# TRAFFIC IMPACT STUDY

## CAP STORAGE FALCON LLC TRAFFIC IMPACT STUDY

El Paso County, Colorado

DATE:  
December 20, 2023

FIGURE 4-4
BACKGROUND FUTURE FORECASTS 2040

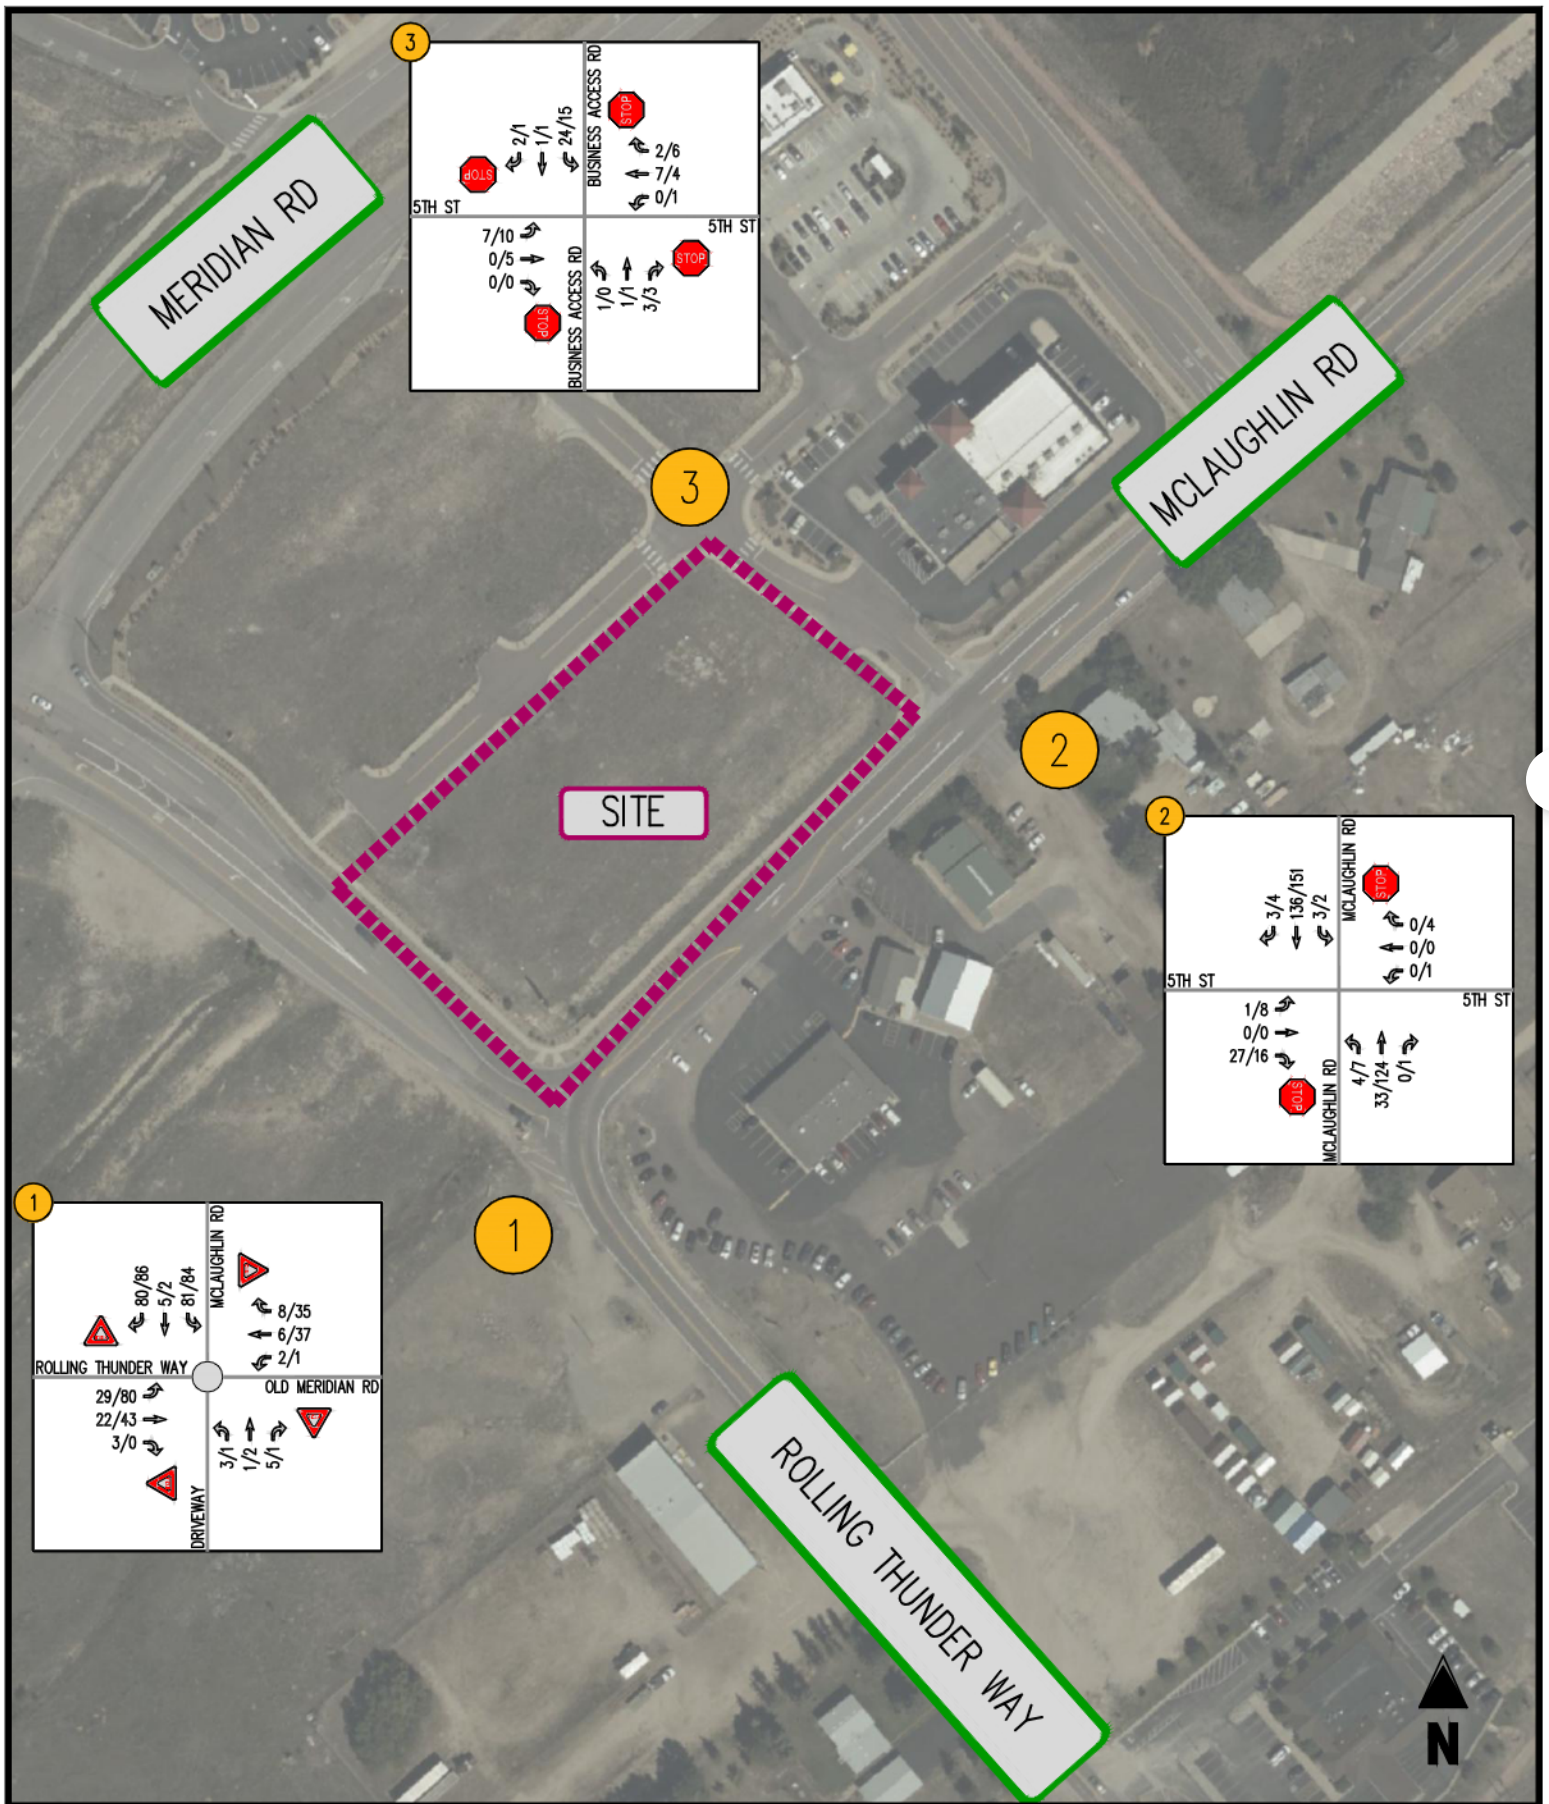
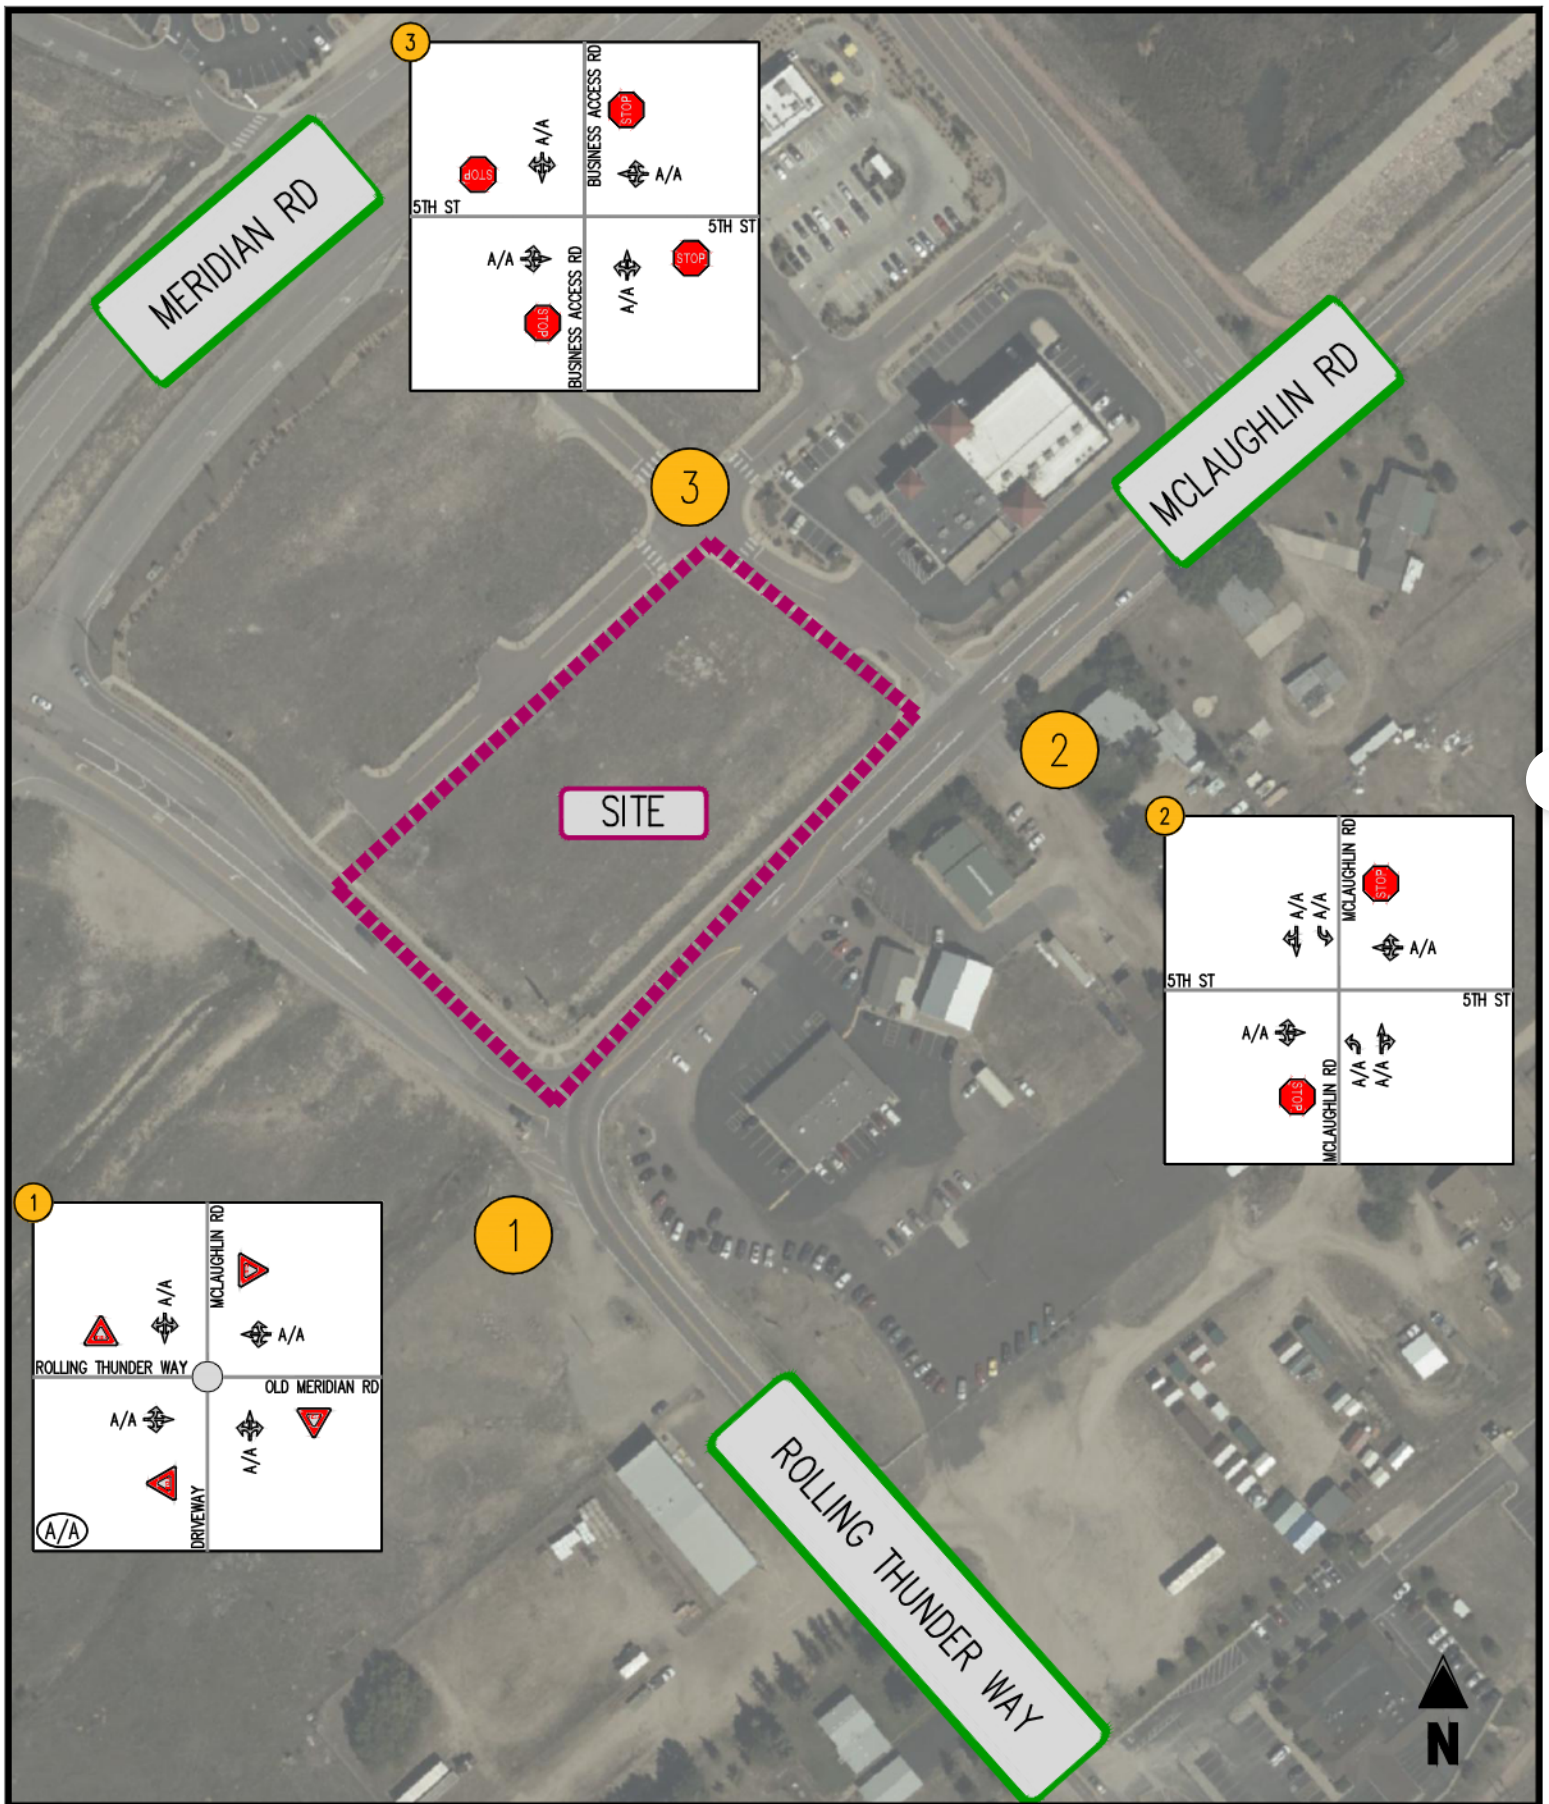
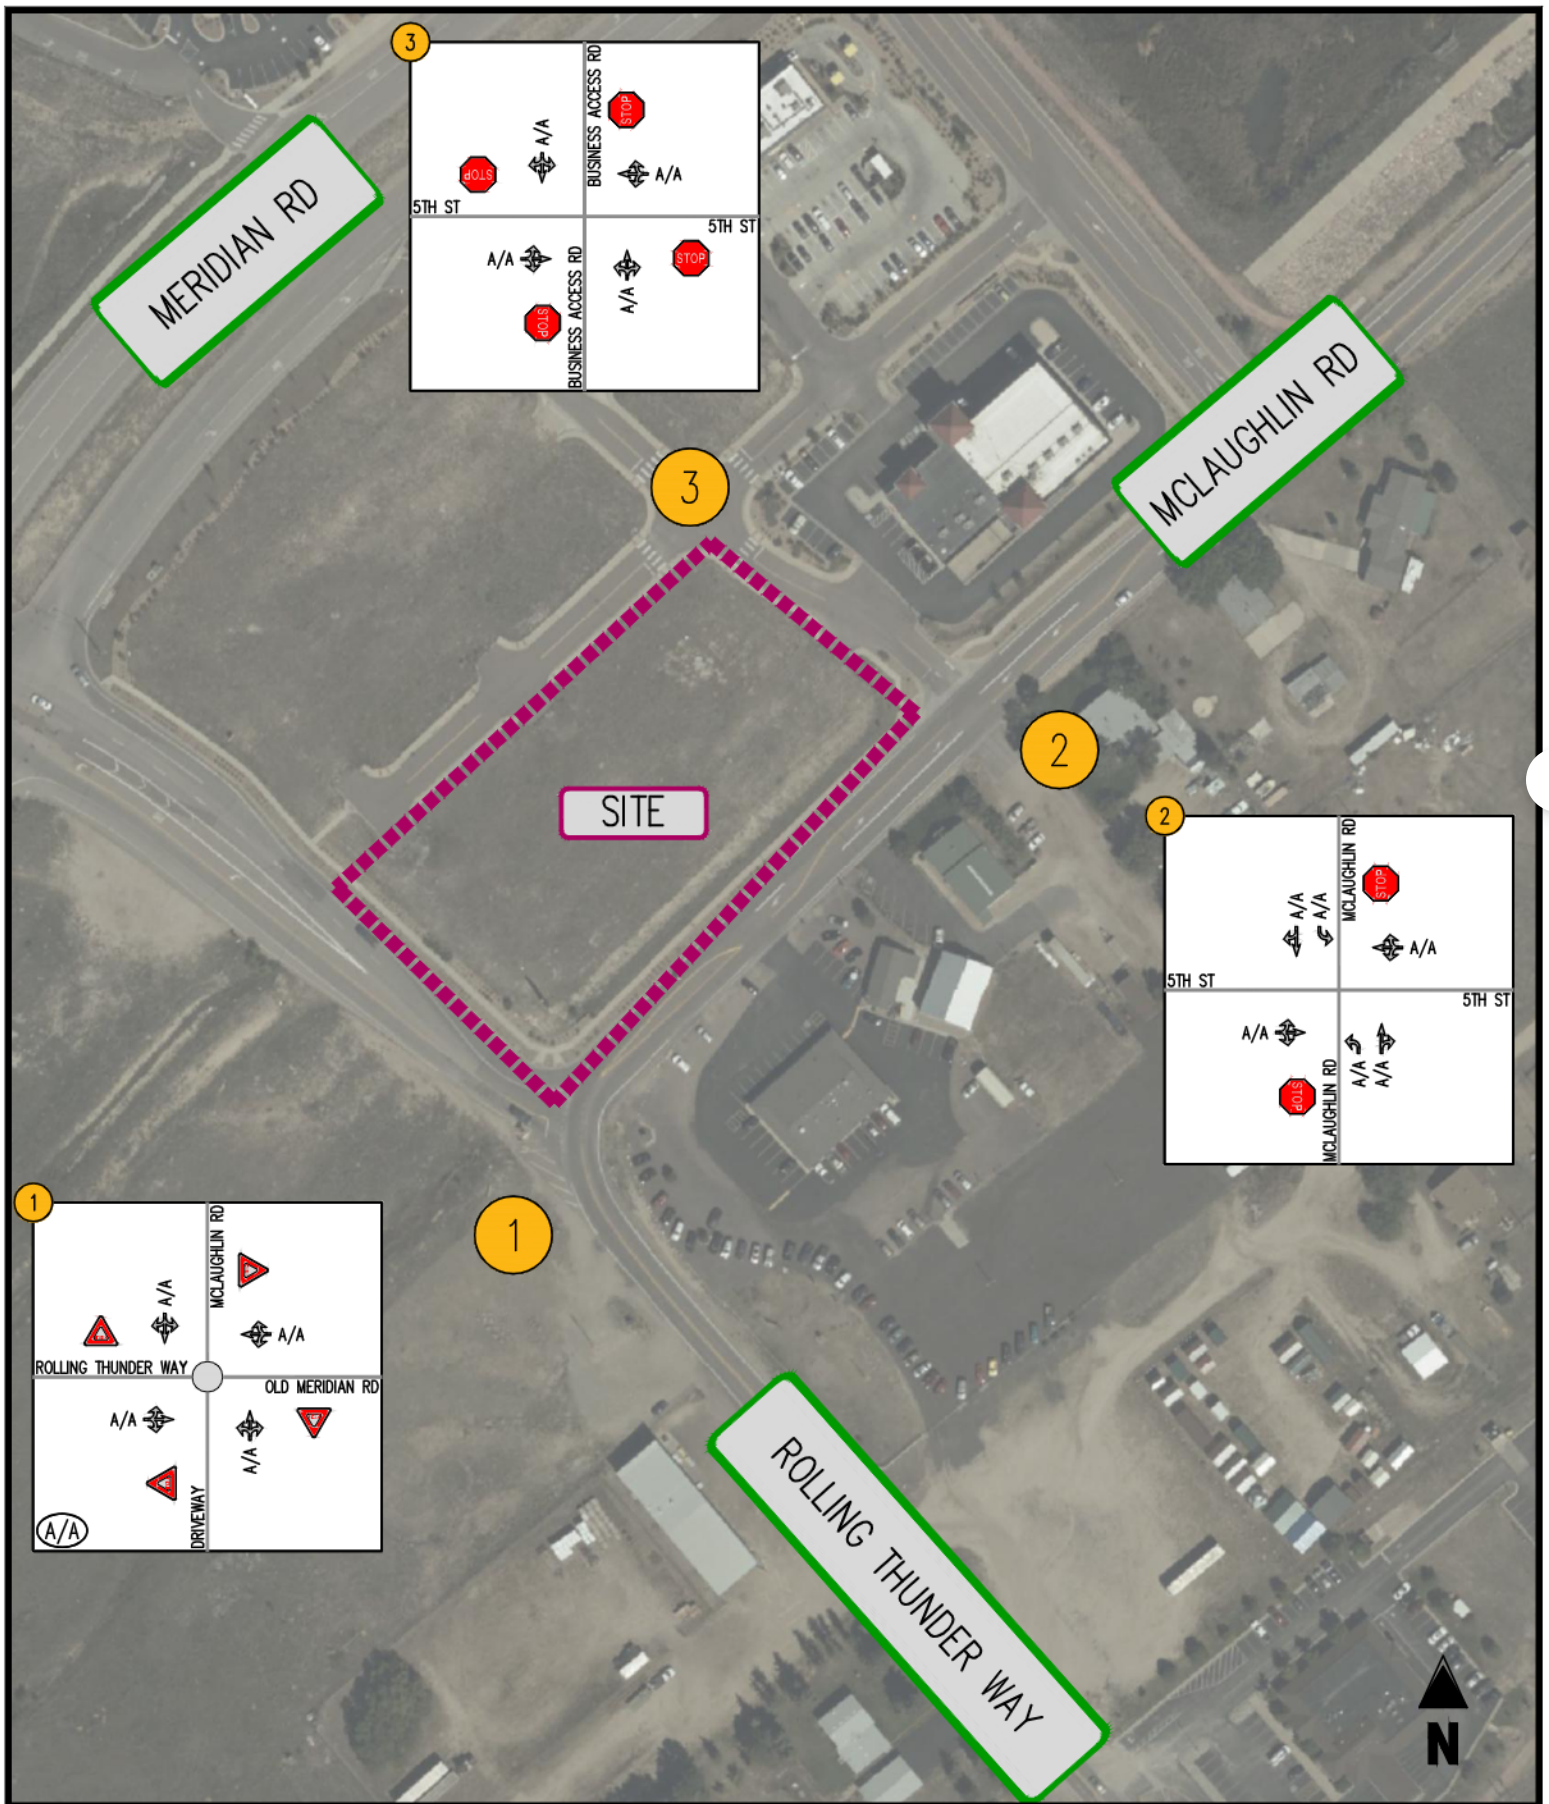
Include long range period for traffic generation and LOS. 2024 is current year. Should see ~2040 See ECM Appdx B Section B.8 Ensure Exhibits are labeled with time horizon
